SUBJECT: Triangle Expressway Southeast Extension (Complete 540) from NC 55 Bypass in Apex to US 64/264 (I-87) in Knightdale, Wake and Johnston Counties; Federal Aid No. STP-0540(19), STP-0540(20), and STP-0540(21); WBS Nos. 37673.1.TA1, 35516.1.TA1, and 35517.1.TA1; STIP Project Nos. R-2721, R-2828, and R-2829

From: Alsmeyer, Eric C CIV USARMY CESAW (USA)
Sent: Friday, August 11, 2023 12:18 PM
To: Ridings, Rob <rob.ridings@deq.nc.gov>; Thomson (Sage Group), Nicole J <ext-njthomson2@ncdot.gov>
Cc: Riffey, Deanna <driffey@ncdot.gov>; Abi Sheffey <asheffey@SAGEECOLOGICAL.COM>; Matthews, Monte K CIV USARMY CESAW (USA) <Monte.K.Matthews@usace.army.mil>
Subject: Mod 13 RE: Complete 540, R2721B Permit Site 9 Mod Request; DA# SAW-2009-02240

**North Carolina Division of Water Resources
Transportation Permitting Unit
In-Field Minor 401 Water Quality Certification Modification**

Project Name/ TIP Project No.: R-2721B; NC Hwy 540 Date: August 11, 2023

PERMIT DRAWING
SHEET 27 OF 69

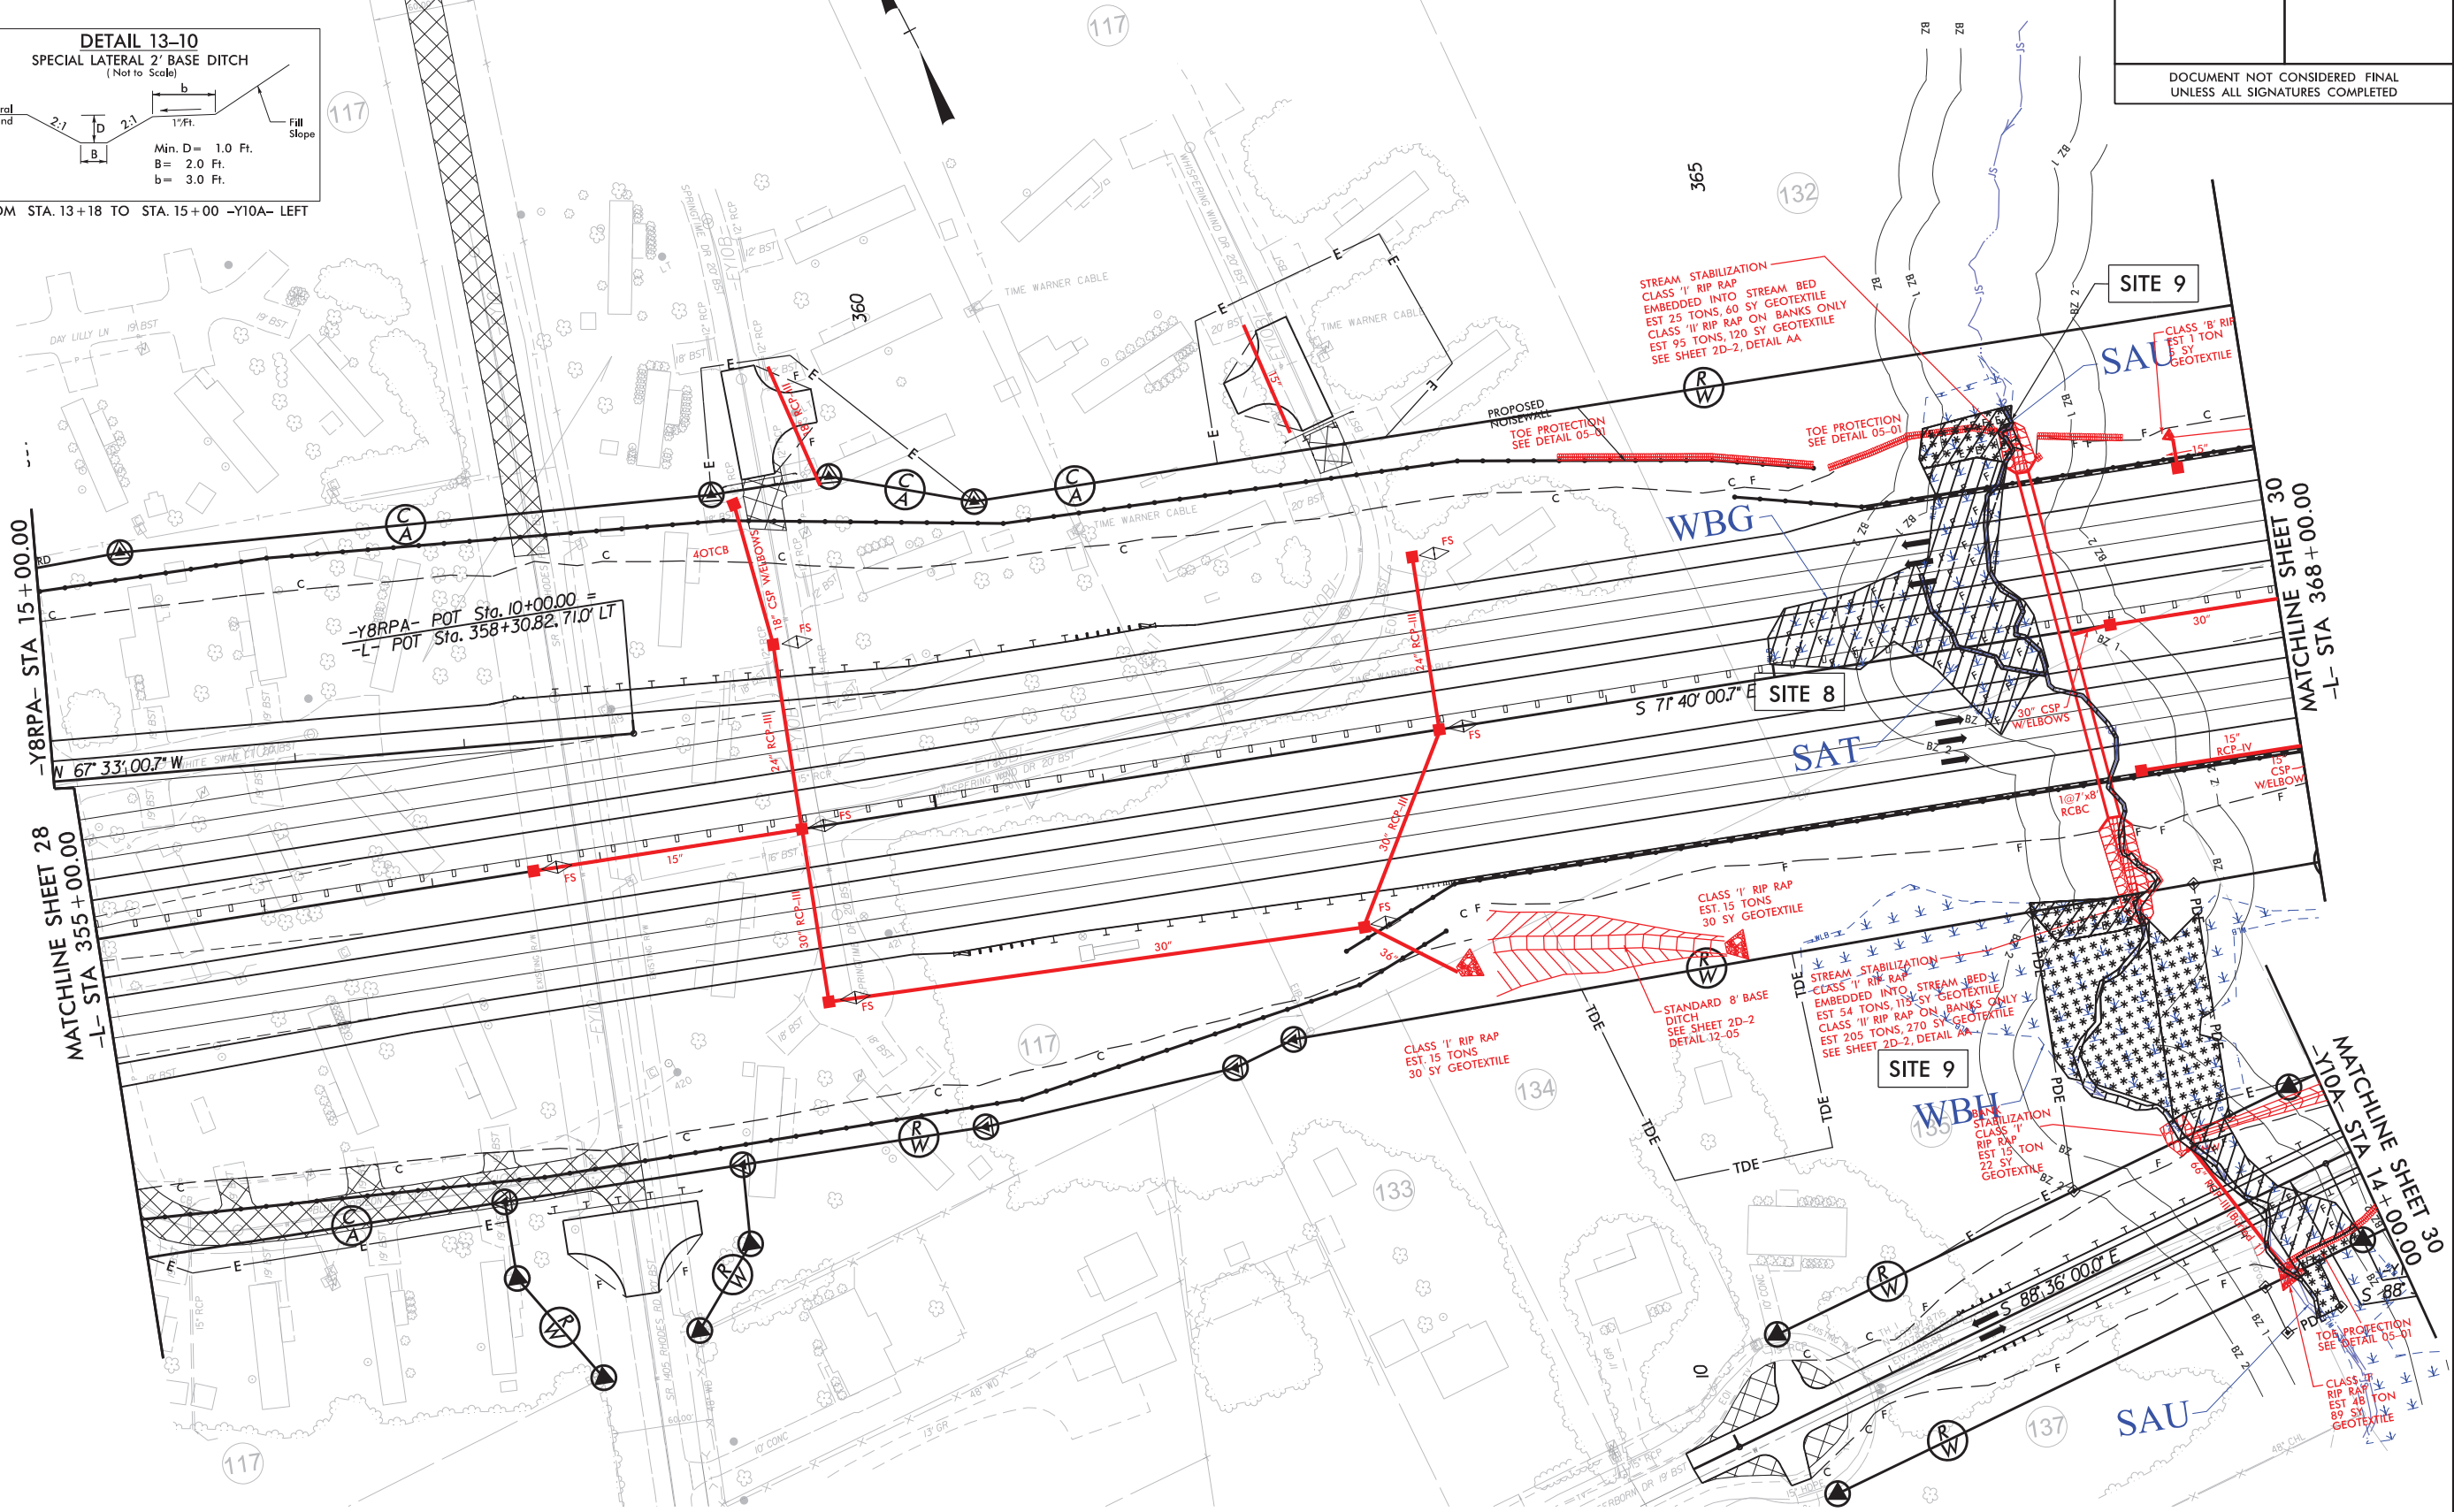
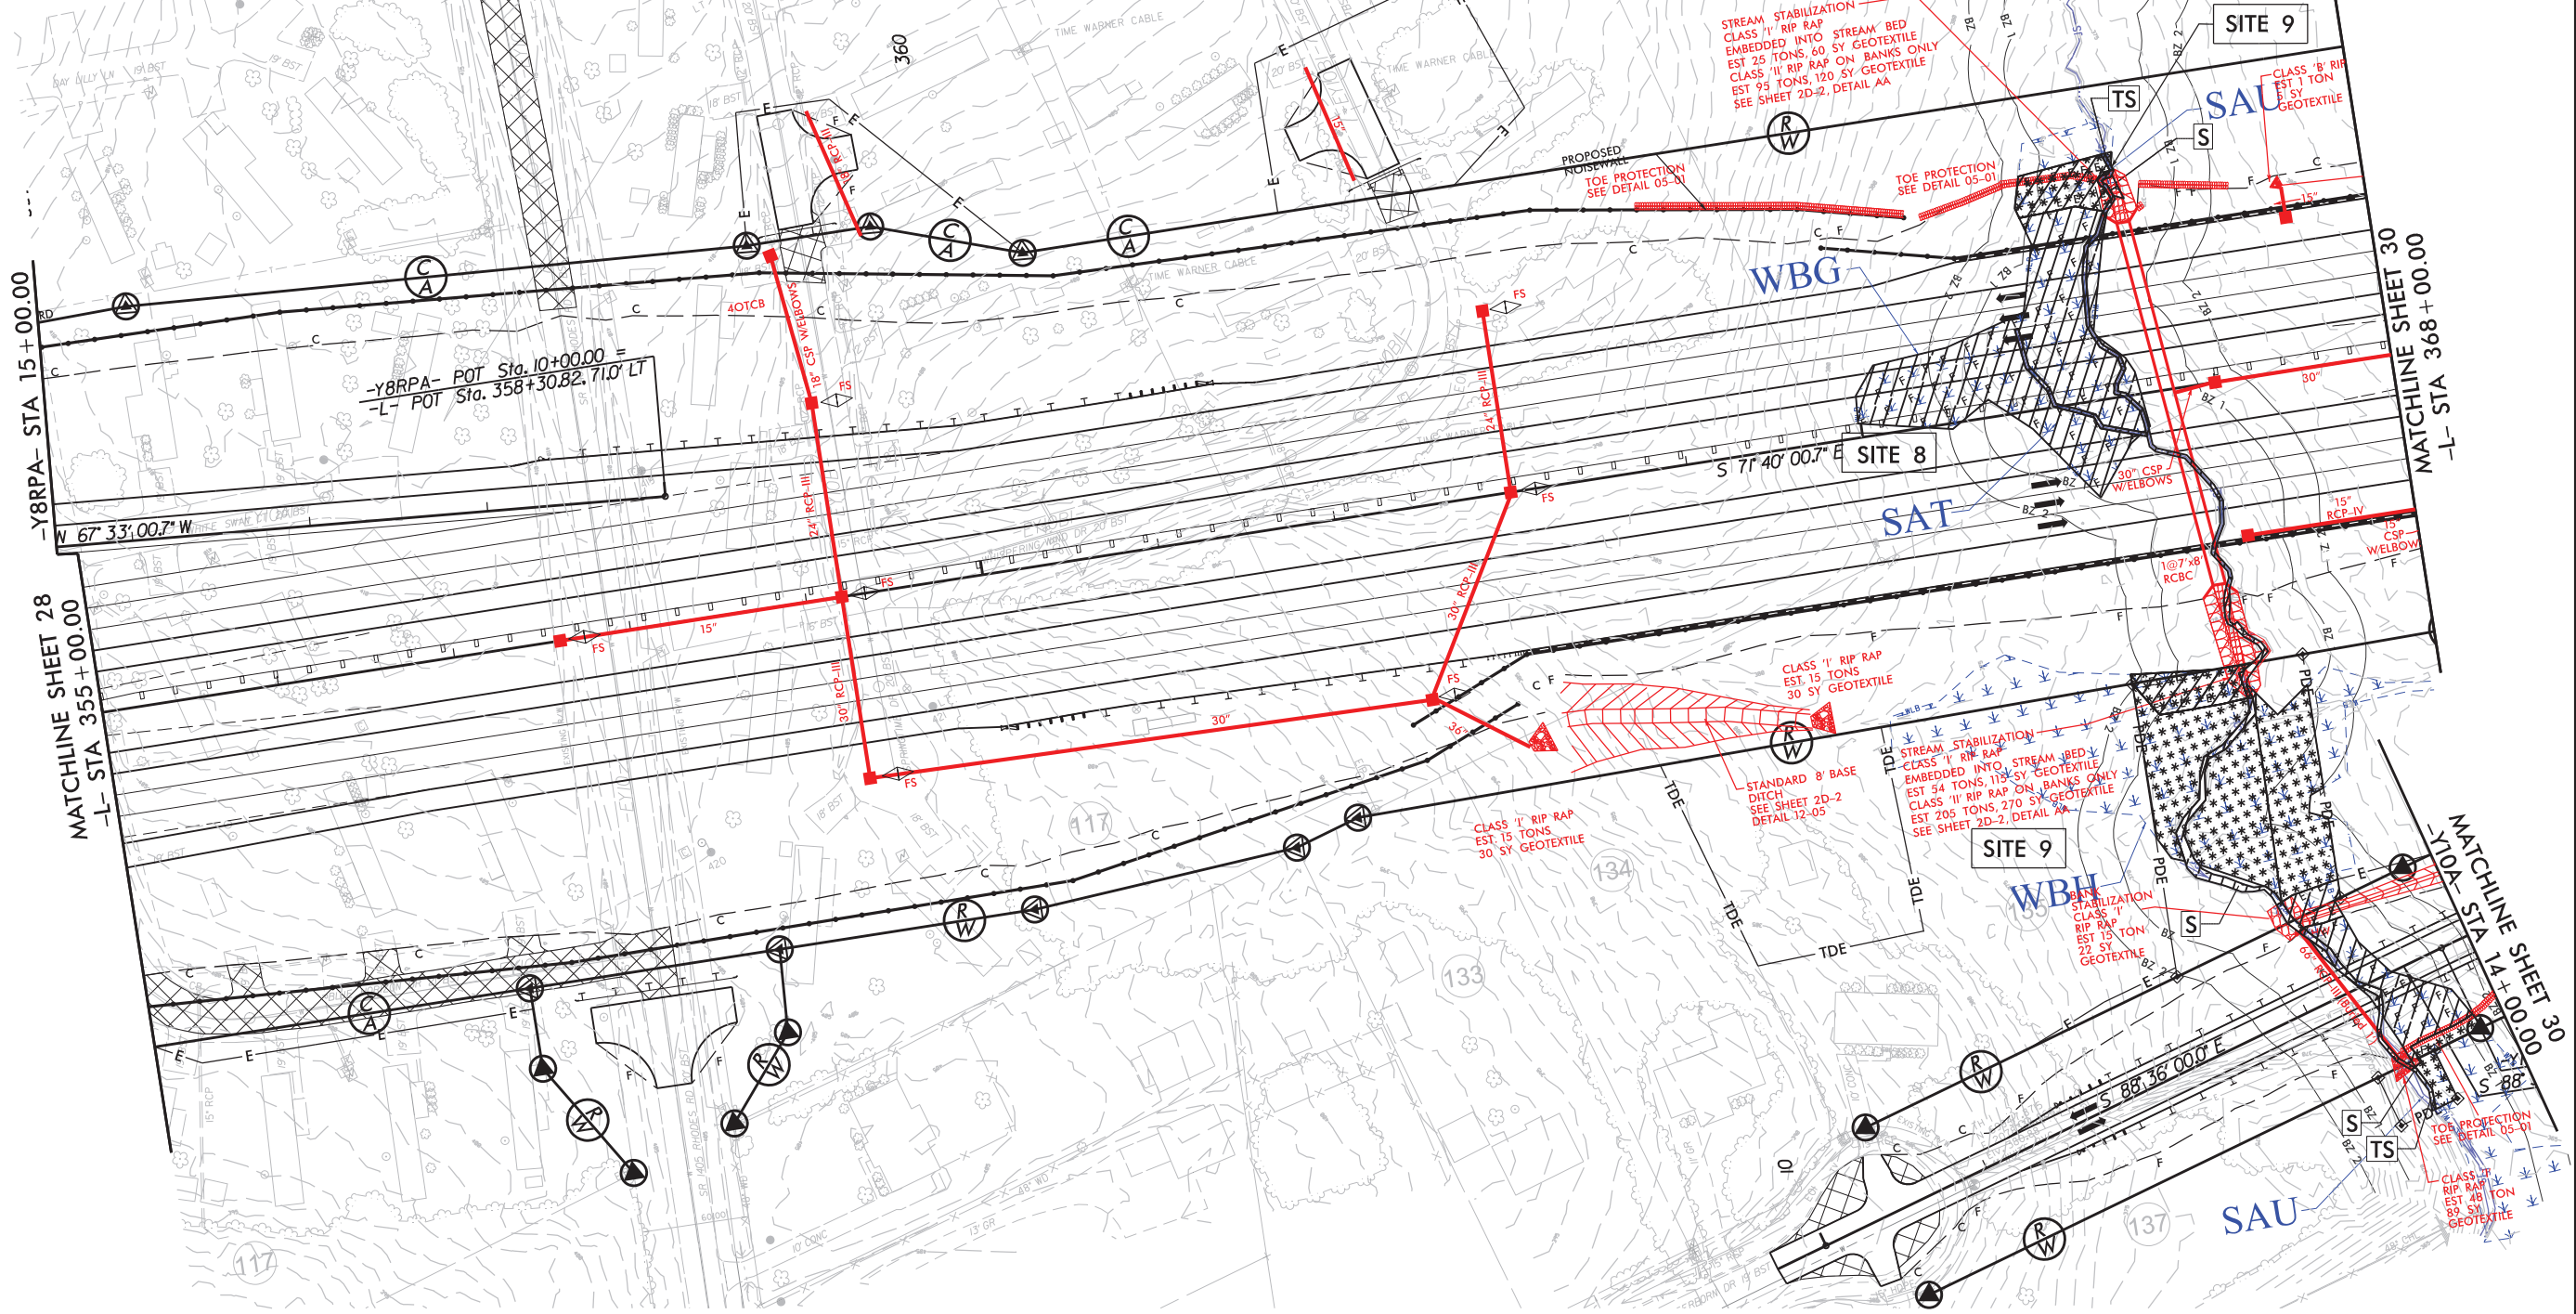
On August 10, 2023, the U.S. Army Corps of Engineers (Corps) received a request from NCDOT to modify the standard permit for the R- 2721B project (Mod13), to adjust impacts at Permit Site 9, under -Y10A. NCDOT noted that the inlet to the 66-inch RCP culvert at Permit Site 9 had destabilized. Therefore, it was determined that additional in-stream stabilization would be needed at the site to prevent further scour at the inlet to this culvert. Total stream impacts at Site 9 would not be changed; however, the stream impact type would be changed from bank stabilization (at the inlet) to countersunk in-stream stabilization. The overall footprint of the site would be unchanged. NCDOT proposes a change in the stream stabilization at the inlet of the 66" RCP on Y10A. Of the 135 feet of previously accounted for impacts (which included bank stabilization at the inlet, the culvert and the outlet rip rap dissipator pad), 20 feet will now be embedded for stream stabilization at the same location at the inlet noted as permanent bank stabilization.

During previous agency site visits, it was noted that the inlet to the 66-inch RCP culvert at Permit Site 9 under -Y10A- had destabilized. Therefore, it was determined that a modification would be necessary to account for additional in-stream stabilization to prevent further scour at the inlet to this culvert. Total stream impacts at Site 9 have not changed; however, the stream impact type has changed at Permit Site 9 from bank stabilization (at the inlet) to countersunk in-stream stabilization. The overall footprint of the site is unchanged. Site 9 now includes stream stabilization at the inlet of the 66" RCP on Y10A due to the ditch tie to the stream and for future stability of not only the channel banks but also the stream bottom. Of the 135 feet of previously accounted for impacts (which included bank stabilization at the inlet, the culvert and the outlet rip rap dissipator pad), 20 feet will now be embedded for stream stabilization at the same location at the inlet noted as permanent bank stabilization. The attached revised permit sheets demonstrate this requested change. The department is not proposing any additional mitigation at this location as countersunk rip rap pads are historically thought of as permanent impact, but not permanent loss of function.

Site 9: During previous agency site visits, it was noted that the inlet to the 66-inch RCP culvert at Permit Site 9 under -Y10A- had destabilized. Therefore, it was determined that a modification would be necessary to account for additional in-stream stabilization to prevent further scour at the inlet to this culvert. Total stream impacts at Site 9 have not changed; however, the stream impact type has changed at Permit Site 9 from bank stabilization (at the inlet) to countersunk in-stream stabilization. The overall footprint of the site is unchanged. Site 9 now includes stream stabilization at the inlet of the 66" RCP on Y10A due to the ditch tie to the stream and for future stability of not only the channel banks but also the stream bottom. Of the 135 feet of previously accounted for impacts (which included bank stabilization at the inlet, the culvert and the outlet rip rap dissipator pad), 20 feet will now be embedded for stream stabilization at the same location at the inlet noted as permanent bank stabilization. The attached revised permit sheets demonstrate this requested change. The department is not proposing any additional mitigation at this location as countersunk rip rap pads are historically thought of as permanent impact, but not permanent loss of function. DOT/Turnpike Authority formally requested in-field mod via email dated August 10, 2023. This change results in no change in impact amounts.

Imbed stabilization into streambed instead of just being on banks. Rock will be keyed-in to allow for aquatic life passage while still stabilizing the stream. Change is at R-2721B Site 9.

The Corps has completed the evaluation of your request and has determined that it is appropriate and reasonable, and that no public notice is required for this modification. Therefore, the permit is modified as requested and as shown on the attached

drawings. No additional compensatory mitigation is required.
